MEMORANDUM

DATE: September 25, 2012

SUBJECT: 21 Quiet Lane

AS-BUILT SITE PLAN OF LAND

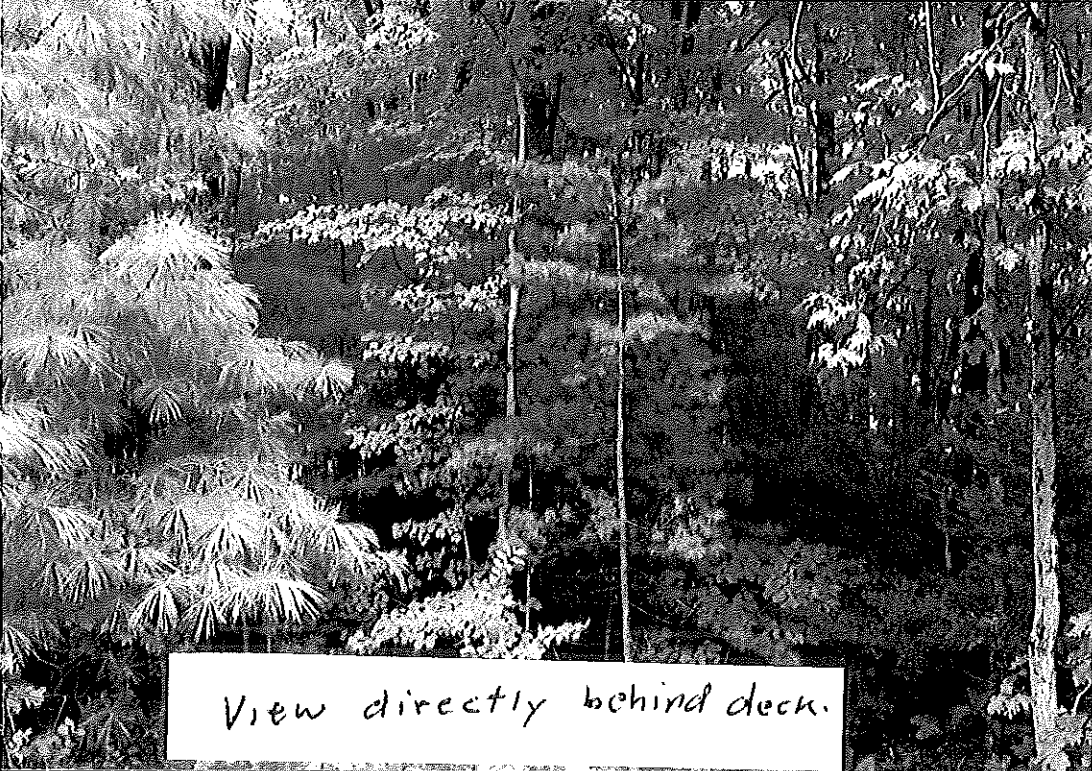
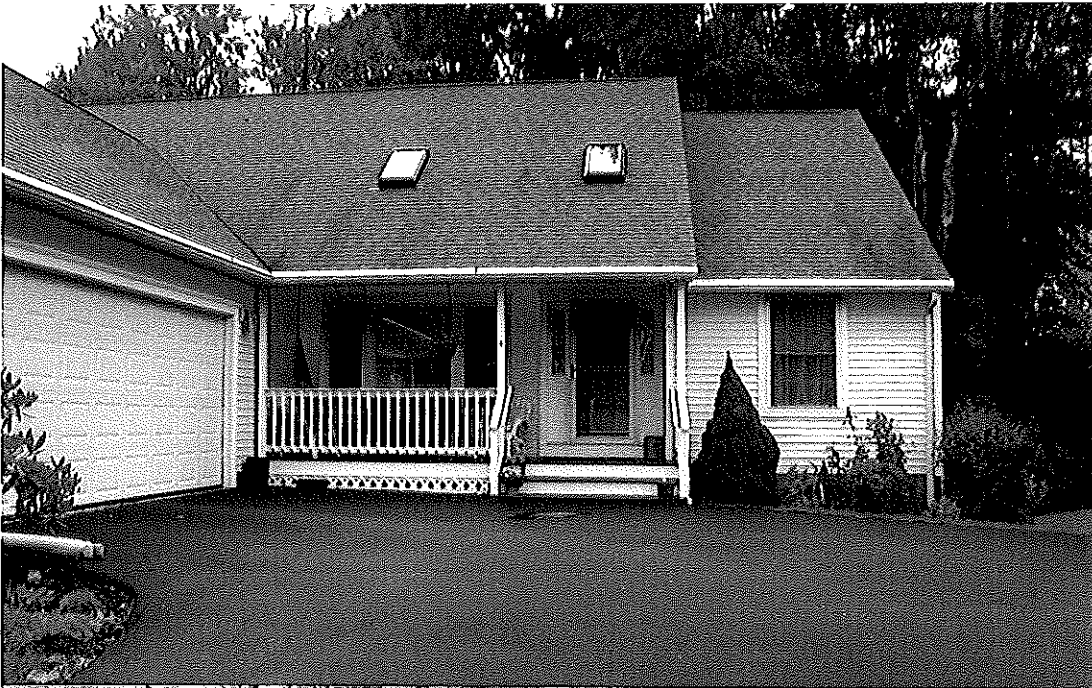
Based upon a review of the file, it appears that the property owner will need to seek an amendment to the subdivision plat from the Planning Board for the deck that extends into the no cut area; however it appears that the deck does not impact a wetland. The existing survey for 21 Quiet Lane shows a shed located in the no-cut area, which should be relocated out of the no-cut buffer.
